Regarding: Project Mars Data Centre - SSD-82052708 - 12 Mars Road, Lane Cove West

Subject: Objection to Proposed Data Centre Development in Lane Cove West

DRAWING TITLE
**GENERAL ARRANGEMENT - ROOF
 PLAN**

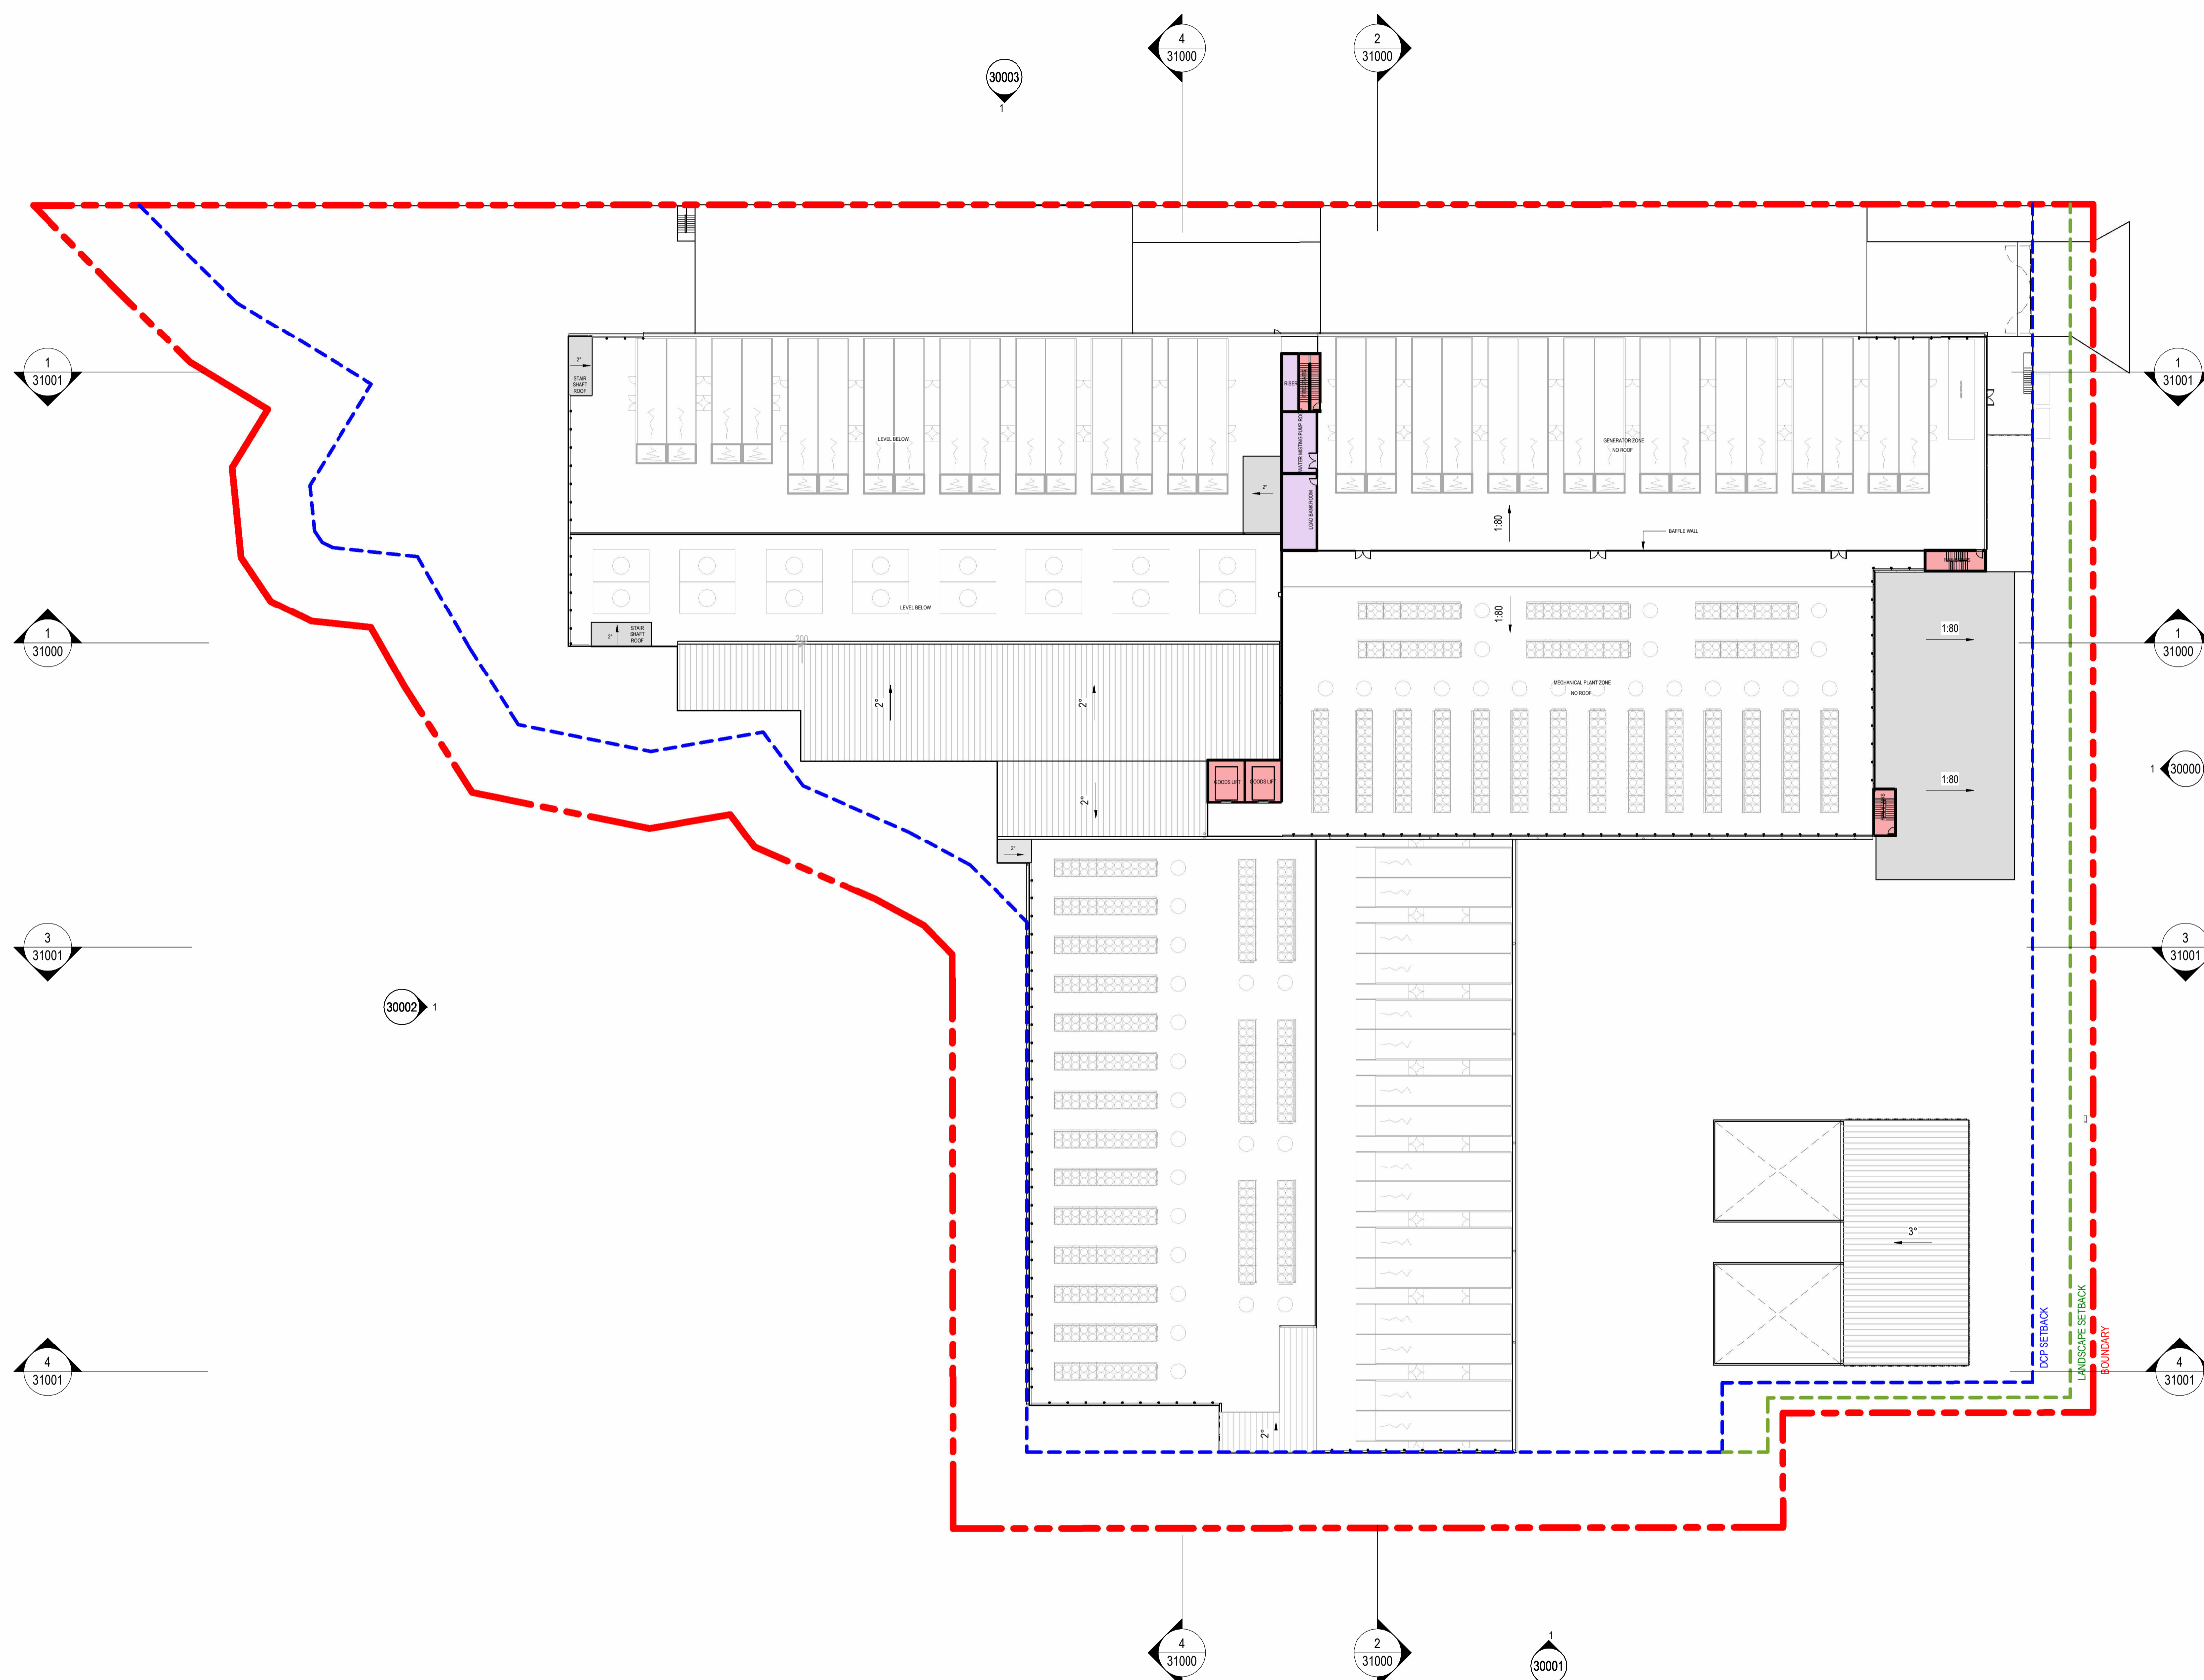
Our enjoyment in living an indoor / outdoor lifestyle will be heavily disrupted.
EIS Appendix U - Noise Impact Assessment Roof Layout	The roof layout in Figure 11 (see <i>Figure 4</i> below) and Table 23 shows multiple point sources of noise with only acoustic louvres proposed to the east and south rooftops of the building. 'The design of the roof louvres, screens and parapets is indicative and will be reviewed during a later design stage of the project.'	Inadequate assessment of actual noise impacts fails to consider the close proximity of residential properties to this development and approval should not be granted on this basis. Fails to demonstrate achievement of SEARS Additional Assessment Criteria Operational Noise . The noise impacts generated from the mechanical plant have not been sufficiently assessed as reporting only includes indicative noise levels for examples of typical plant and machinery, and indicative design of roof louvres, screens and parapets, not the proposed detailed design plant. By using assumptions without detailed design, the noise assessment cannot accurately predict noise impacts and adherence with regulatory noise limits.

1 EAST ELEVATION
1 : 500

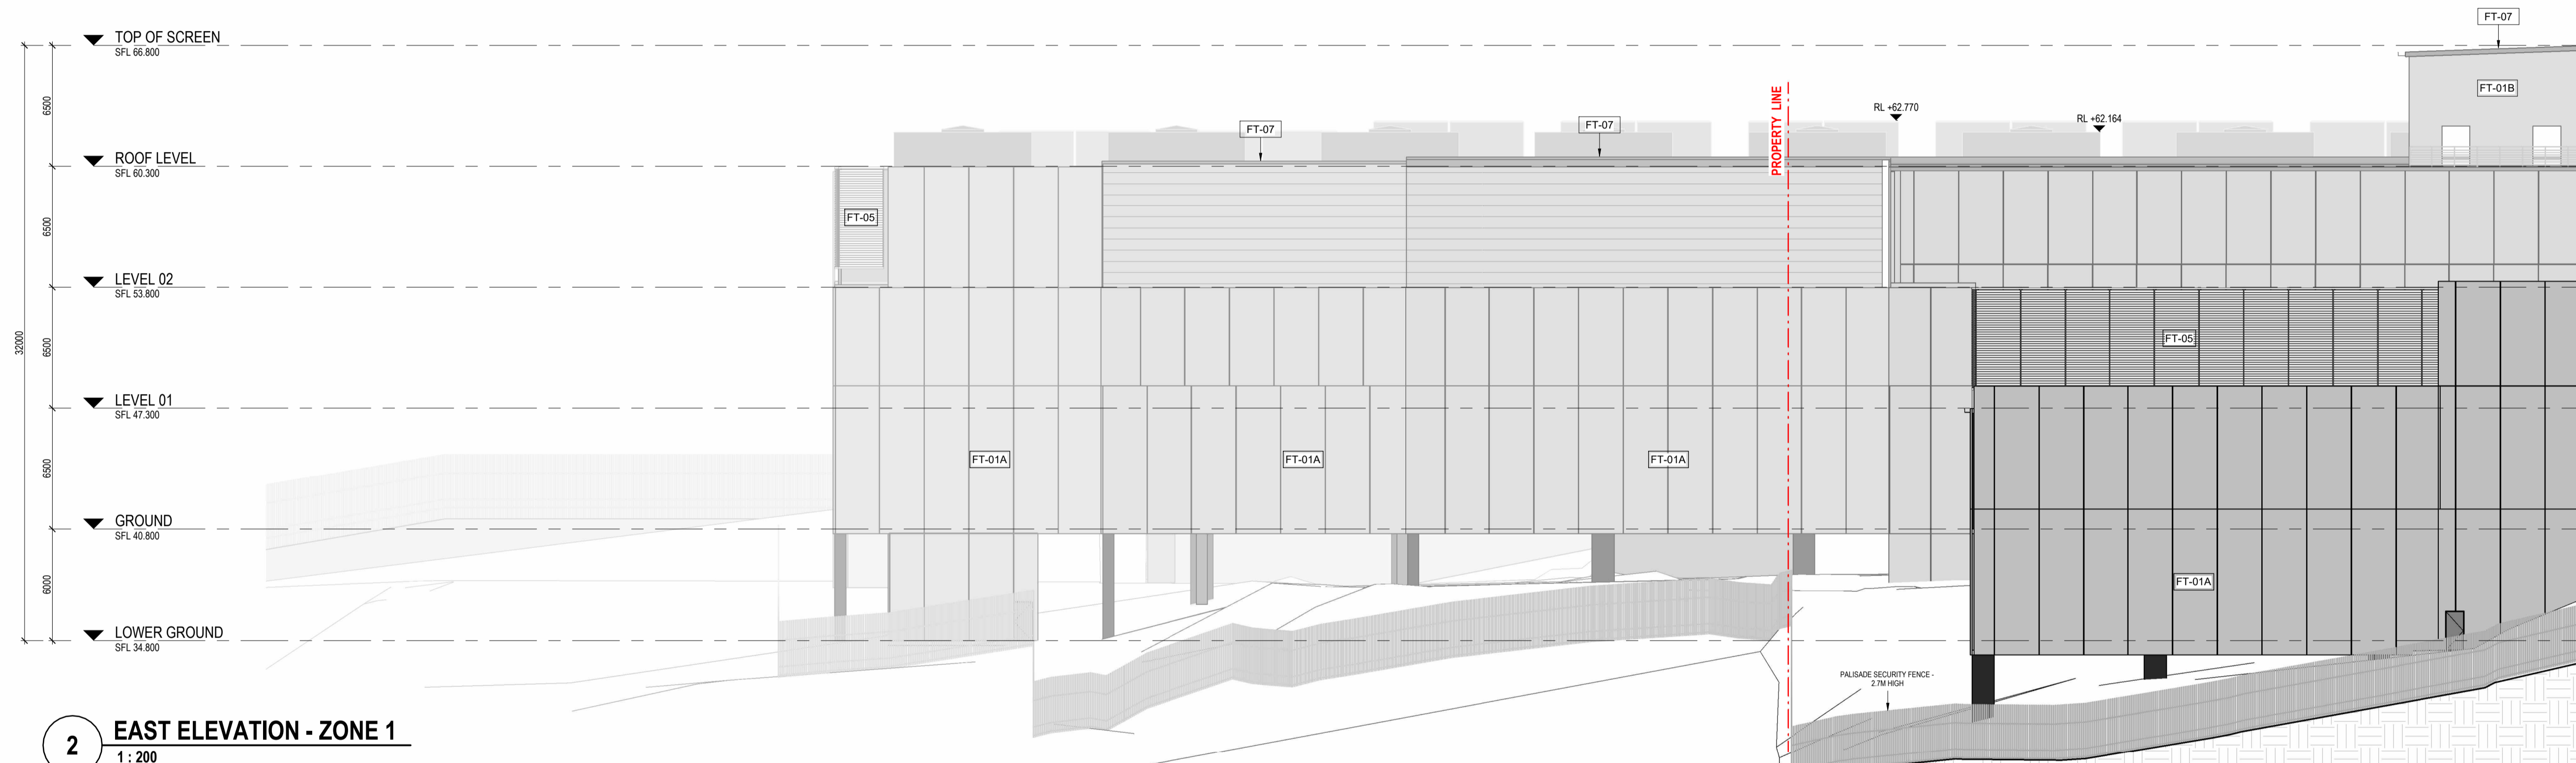
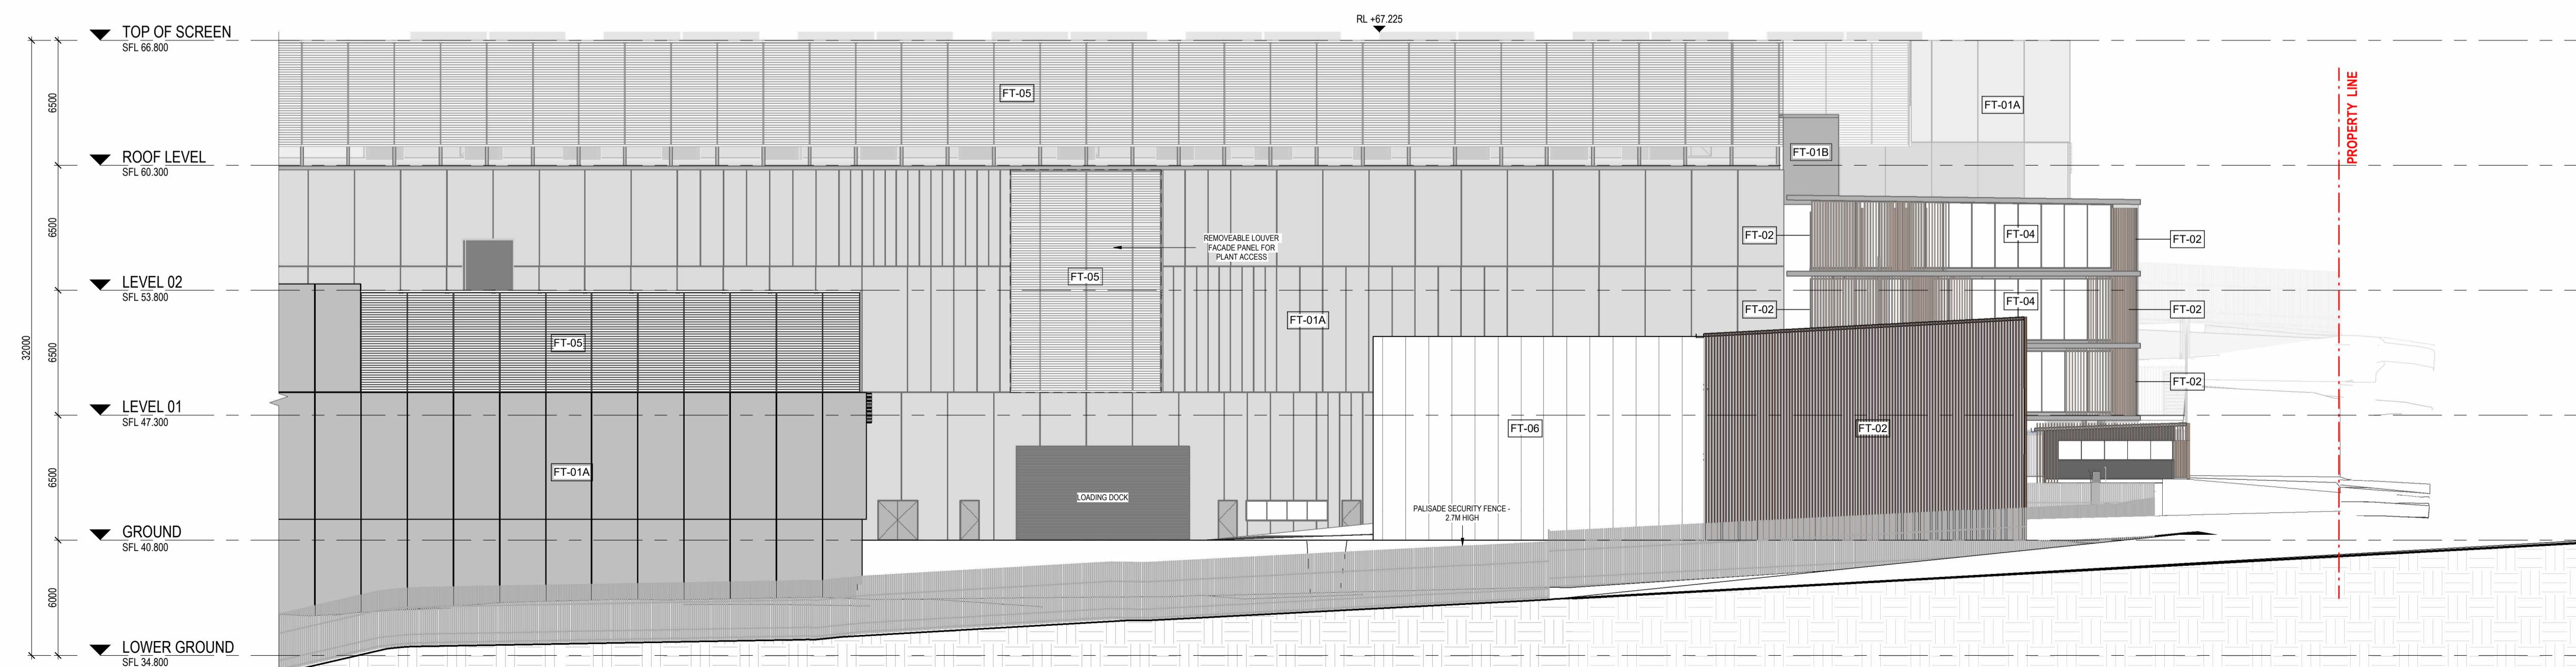
Building B contains data halls, roof-top cooling towers, associated plant and back-up generators. The building is just under 22m tall, breaching the maximum permissible planning height by 10.3m. (rooftop RL 60.3, top of plant RL 62.77). At its closest, this building is 26m taller than our house.

Figure 2 uses Architectural drawings (EIS Appendix B) and reduced levels provided to give an approximate visualisation of the scale of our residence compared to the proposed development. At only 50m away, this development is a giant compared to the current and surrounding land use and will have an unacceptable visual impact on our home.
